**CONSULTATION UNDER THE TOWN AND COUNTRY PLANNING
(DEVELOPMENT MANAGEMENT PROCEDURE ENGLAND) ORDER 2015**

Applicant:	Dandara Ltd
Planning Application Reference:	WA/99/20/DOC
Proposal:	Approval of details reserved by condition imposed under ref APP/C3810/V/16/3143095 (WA/22/15/OUT) relating to Condition Nos 6 - materials and finishes, 12 - surface water drainage, 13 - infiltration of surface water drainage, 14 - maintenance & management of SuDs, 15 - foul drainage and 27 - emergency access from site onto Arundel Road
Location:	Land To East Of Fontwell Racecourse Fontwell Avenue Eastergate BN18 0SW
Date:	17 February 2021

Portsmouth Water have reviewed the discharge of conditions 12, 13, 14, and 15 relating to outline planning permission WA/22/15/OUT. The site is located in a high sensitivity groundwater environment, the majority of the site is located in Source Protection Zone 1 c (SPZ1c) and in North West located in SPZ1 for an essential public water supply source. The SPZ1c relates to subsurface activity only, where the Chalk aquifer is confined and may be impacted by deep drilling activities. Subterranean activities may pose a risk to groundwater quality and the local public wa

FON-182-02-A

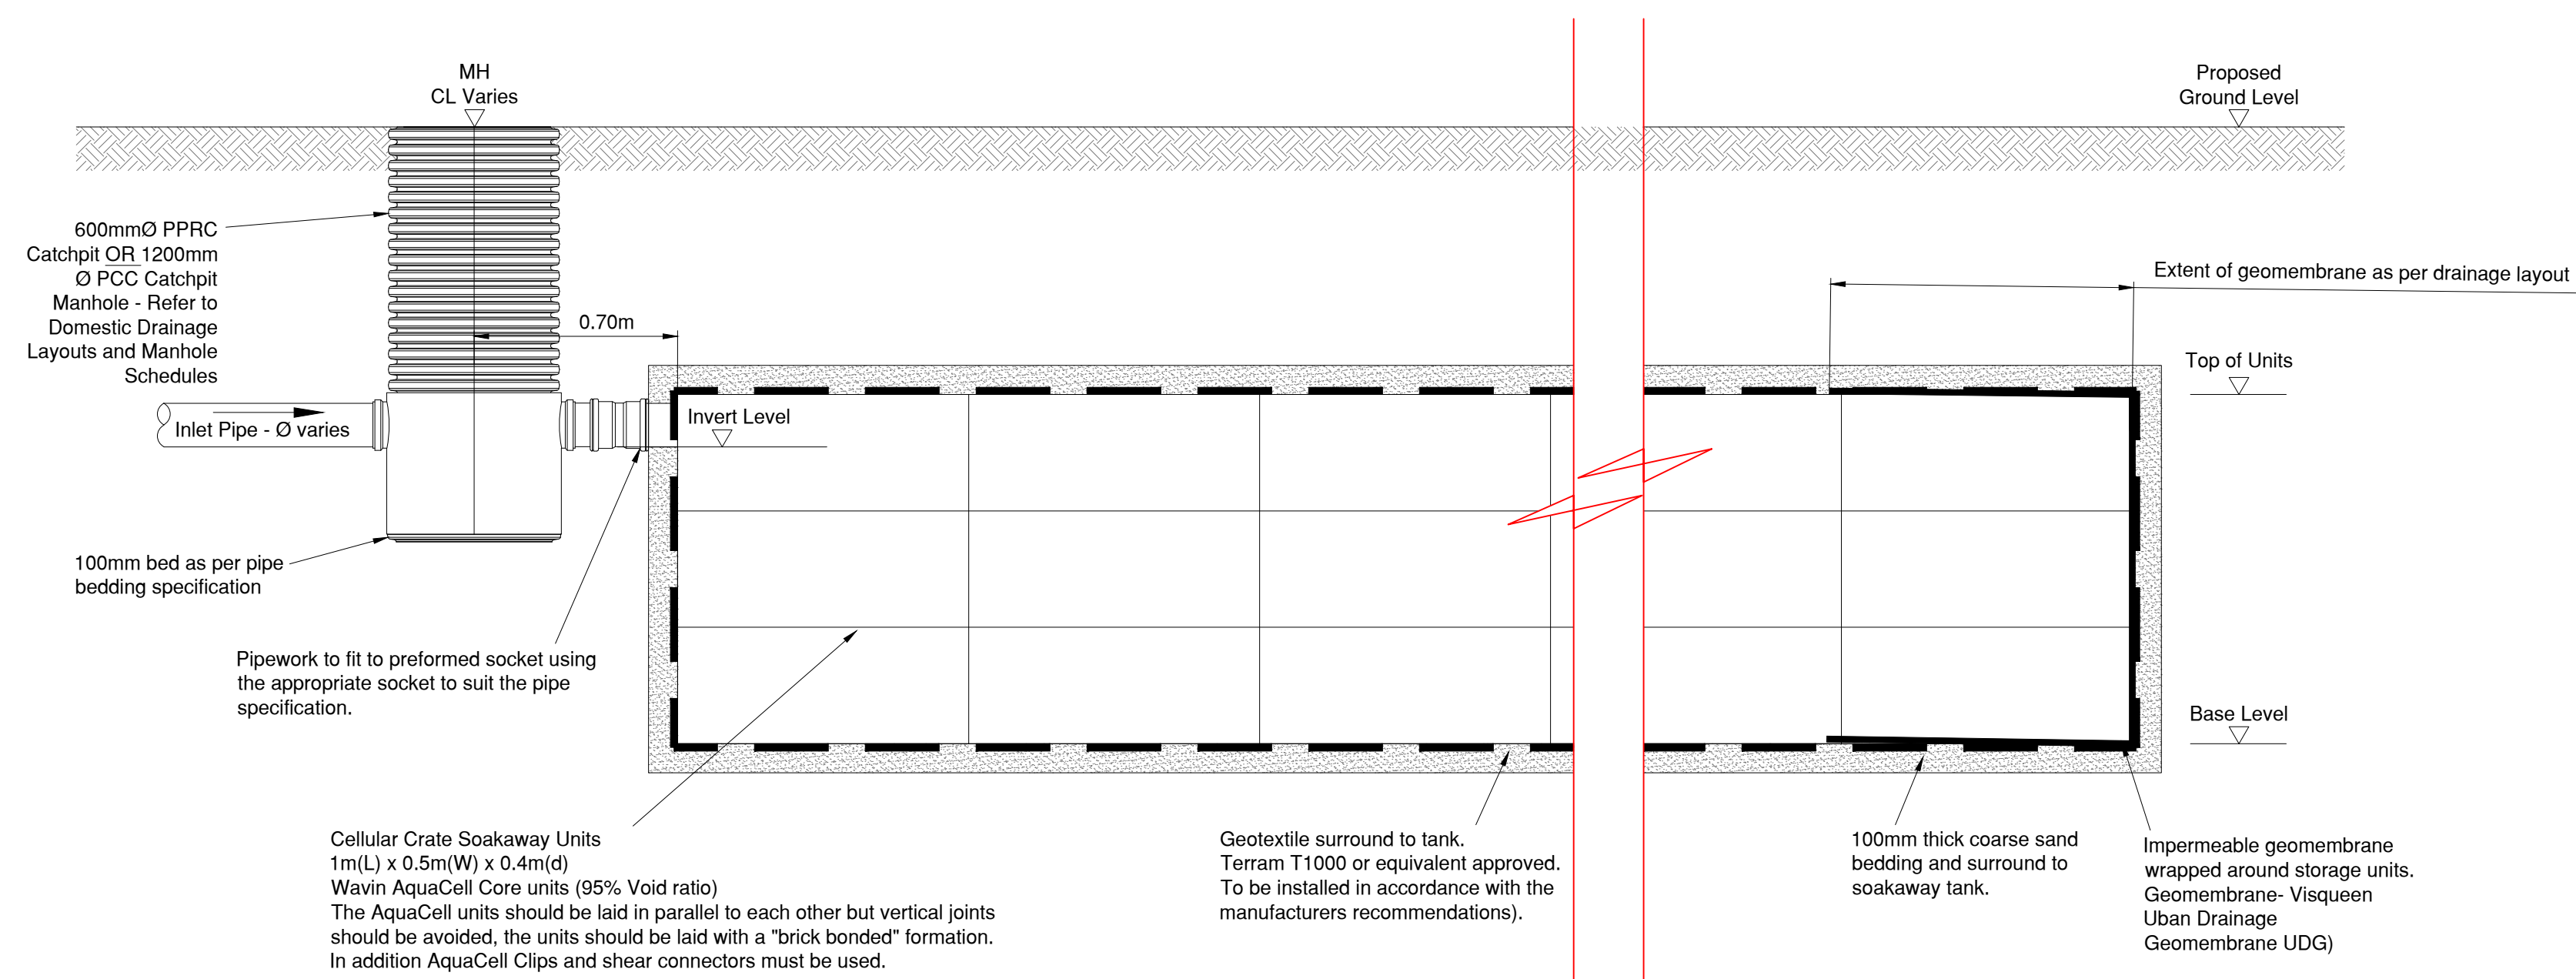
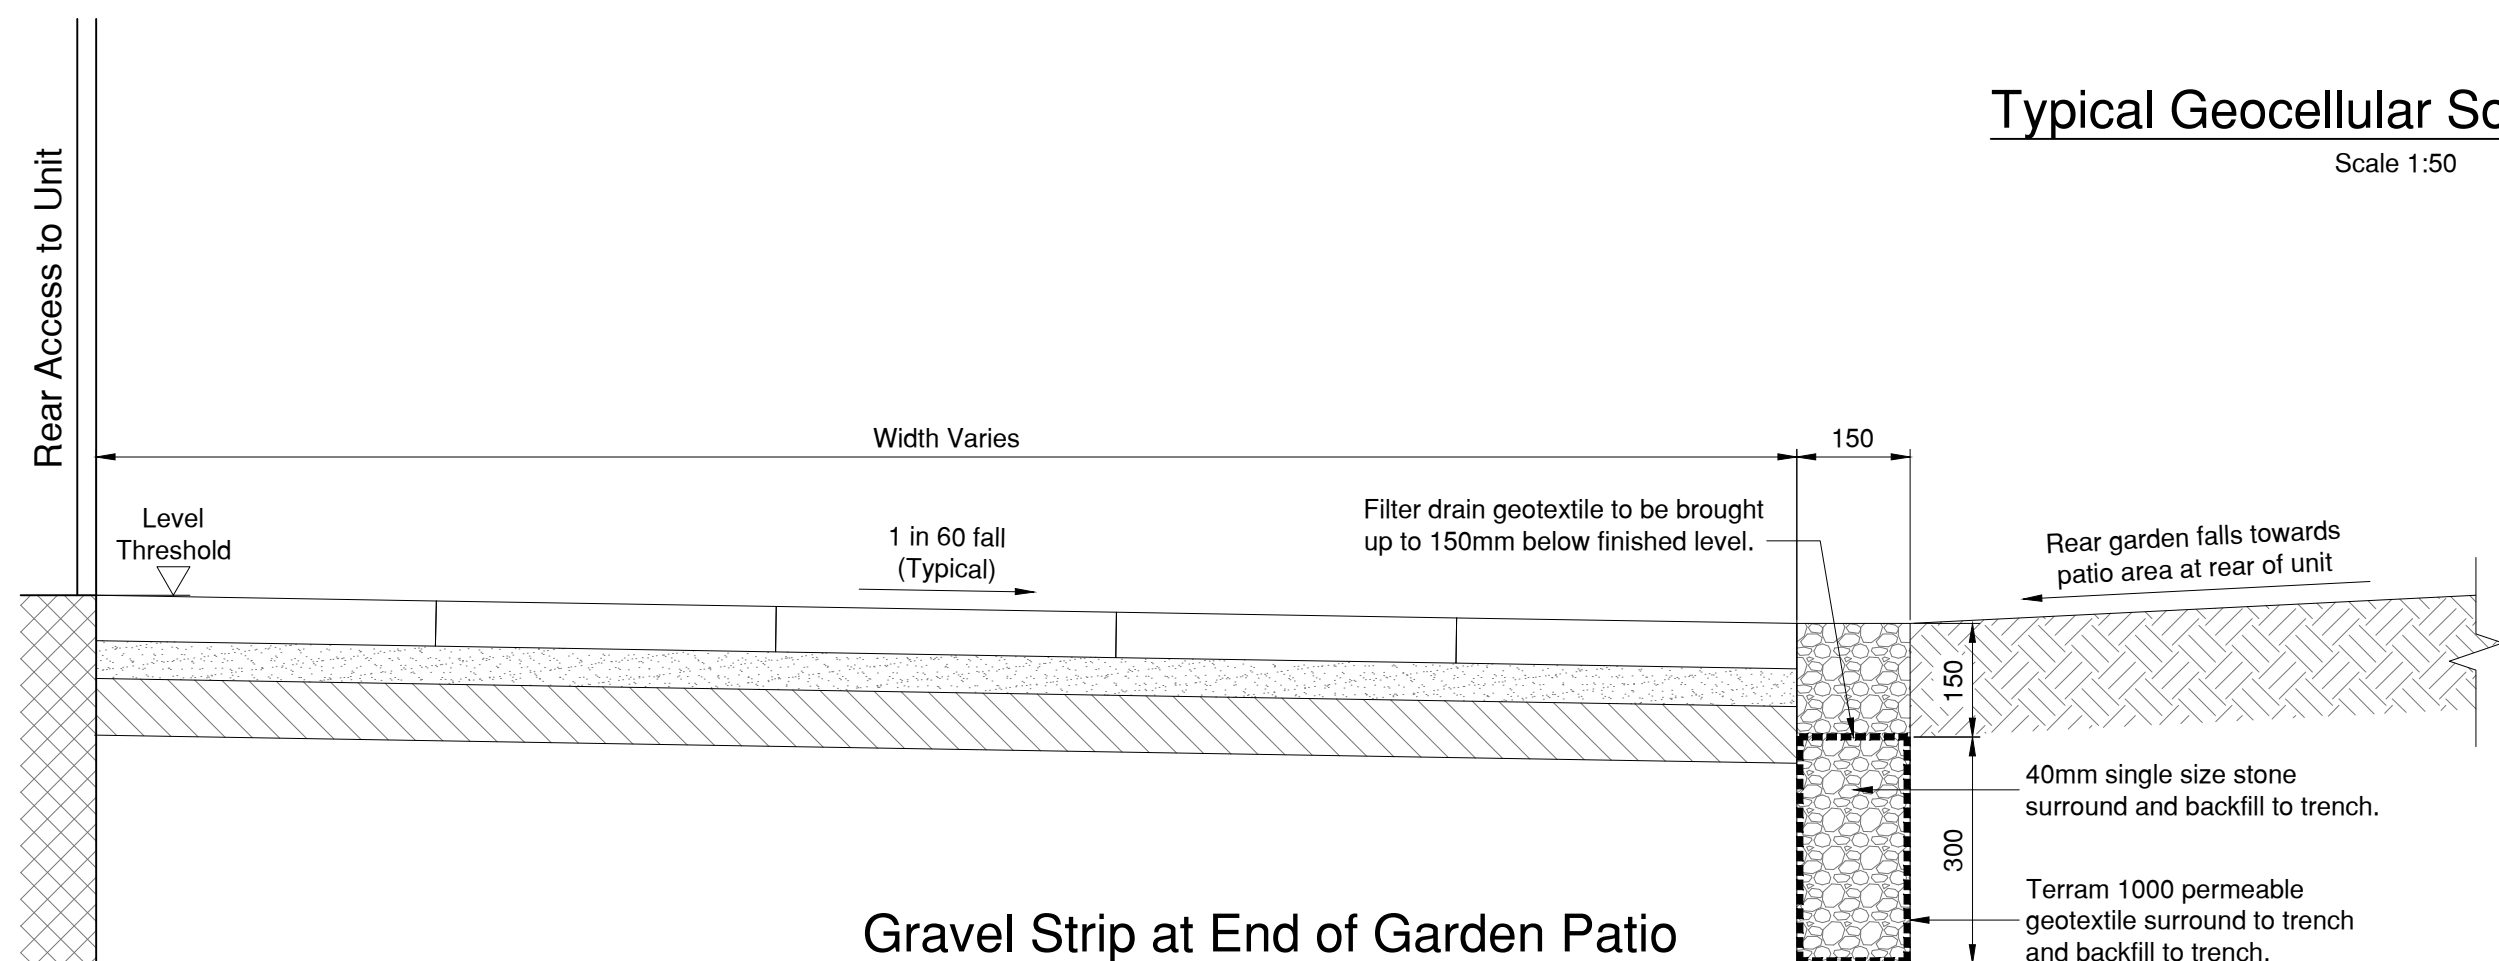
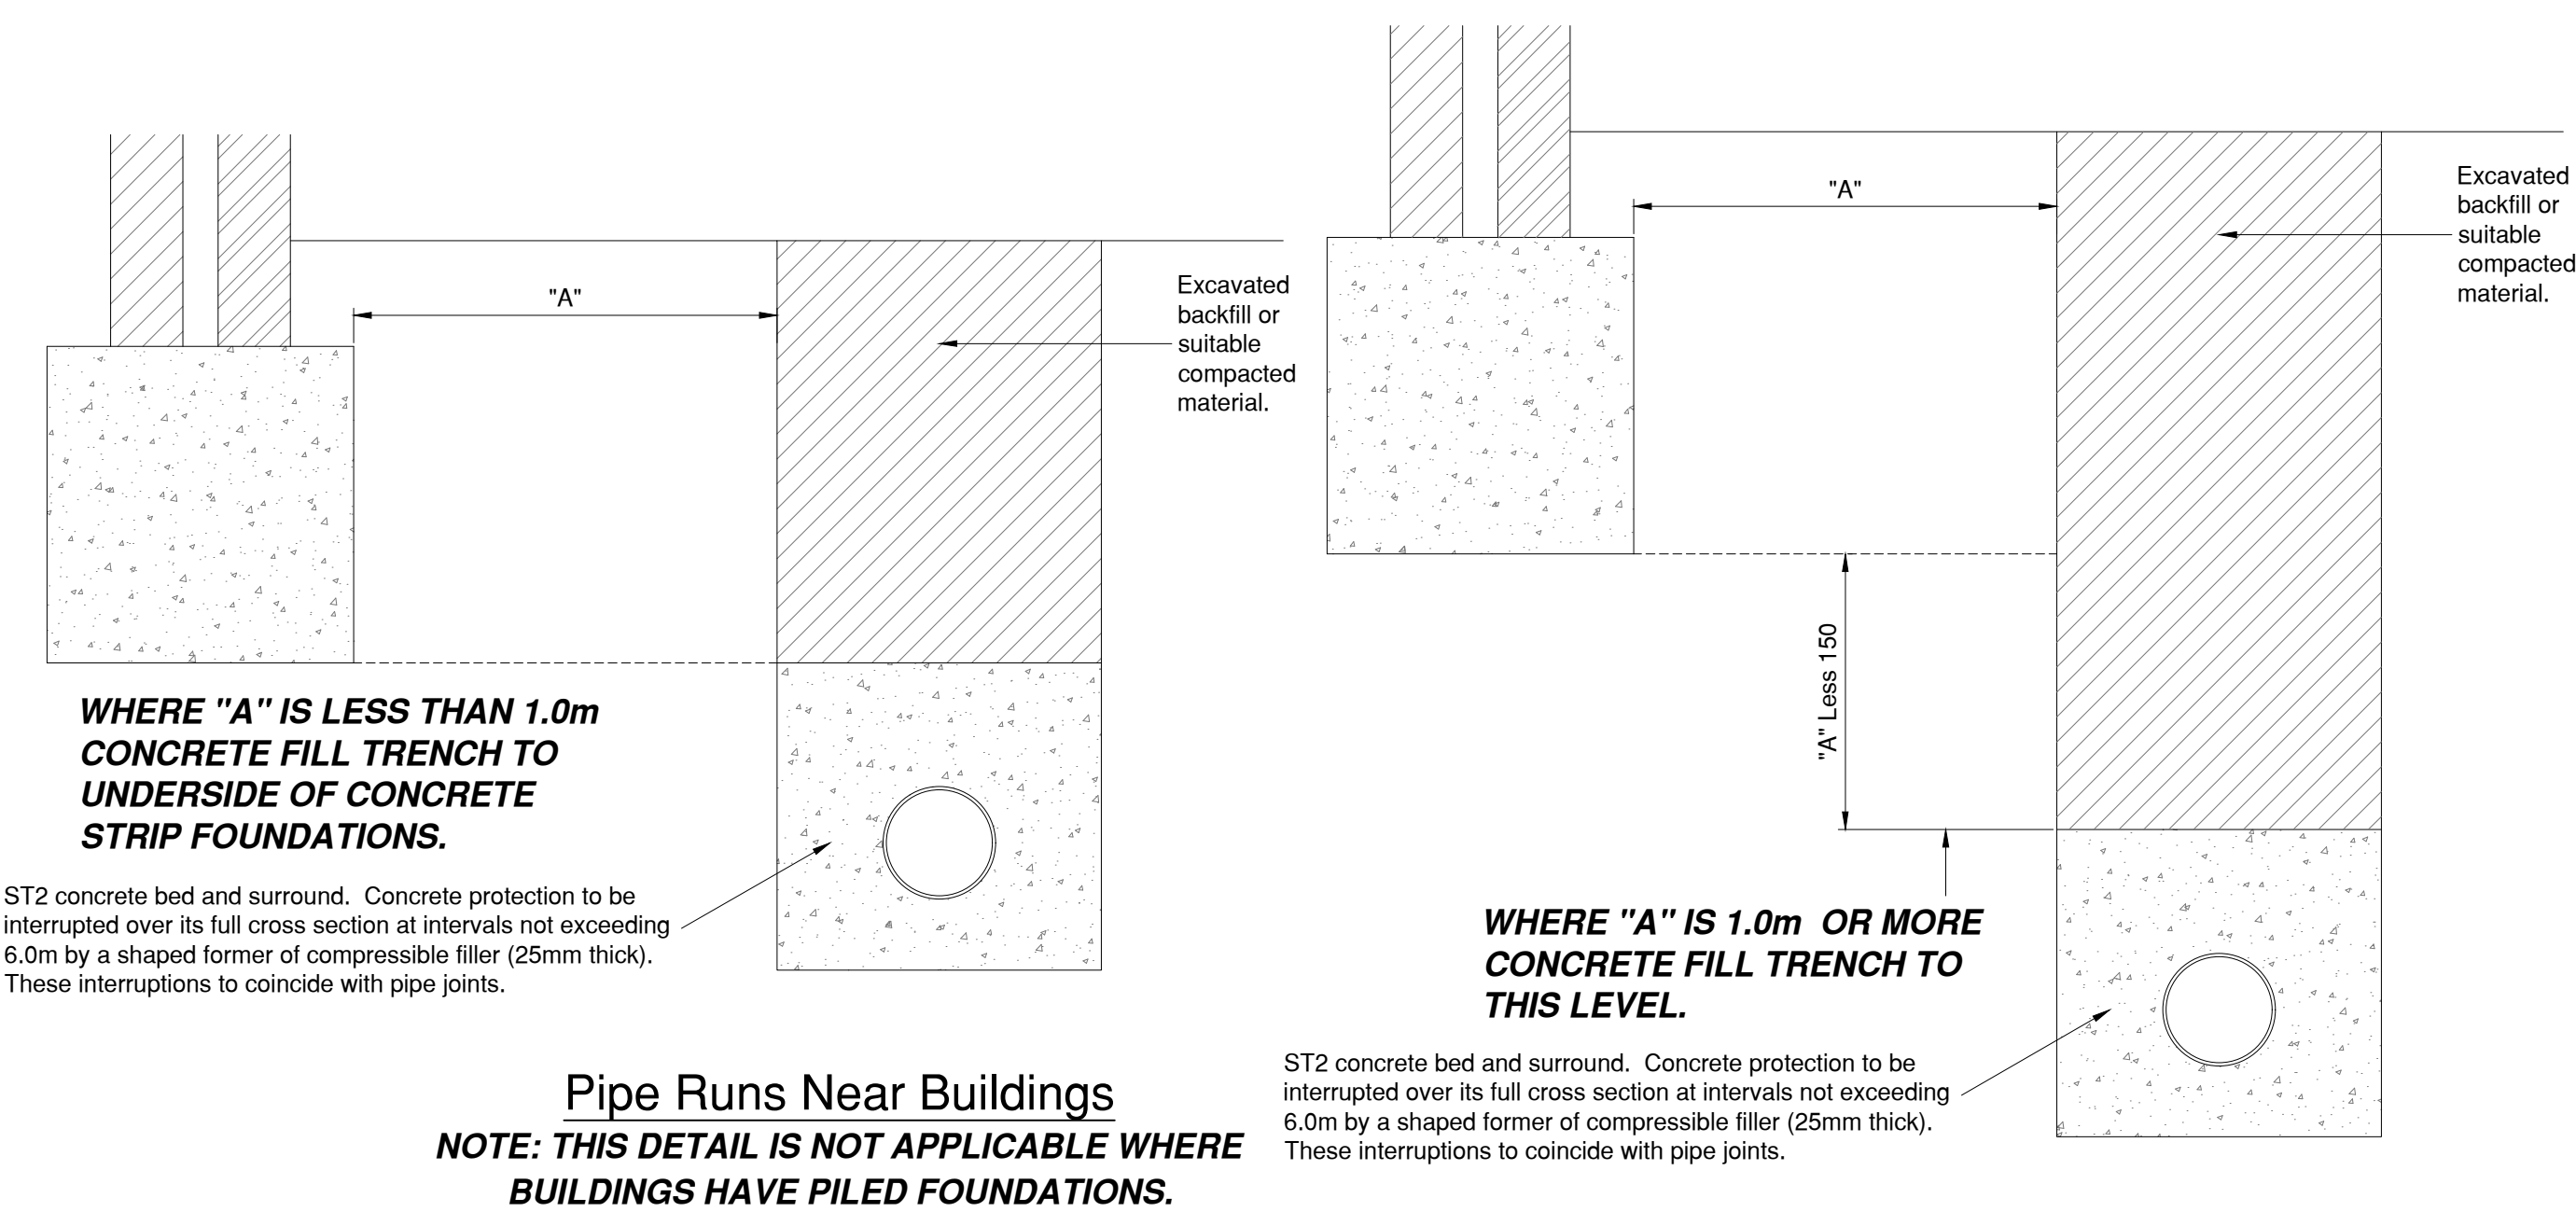
Construction details have been provided in the Domestic Drainage Construction Details Sheets 1 and 2 (FON-182-01-A and FON-182-02-A). Soakaway details have also been provided in drawings (FON-133-01-A, FON-133-02-A , FON-133-03-A). The infiltration drainage features are to be lined with geomembranes. Specifications have been provided for the soakaways and the infiltration basin. According to the specifications the maximum depth of the soakaways is 1.6 mbgl, confirmation of the maximum depth of soakaways would be required to discharge conditions related to infiltration soakaways. There should be a suffice depth of impermeable geology at the base of the infiltration drainage features to protect the underlying aquifer to reduce the risks to groundwater e.g. contamination, turbidity, creation of pollution pathways. We require soakaways to be as shallow as possible to reduce the risk to the underlying aquifer.

Portsmouth Water will be satisfied with the discharge of condition 12 and 13 on the receipt of written confirmation of the maximum depth of all the infiltration features in particular the soakaways. In addition, Portsmouth Water wish to be consulted further if there is any derivations from the existing surface water drainage proposals.
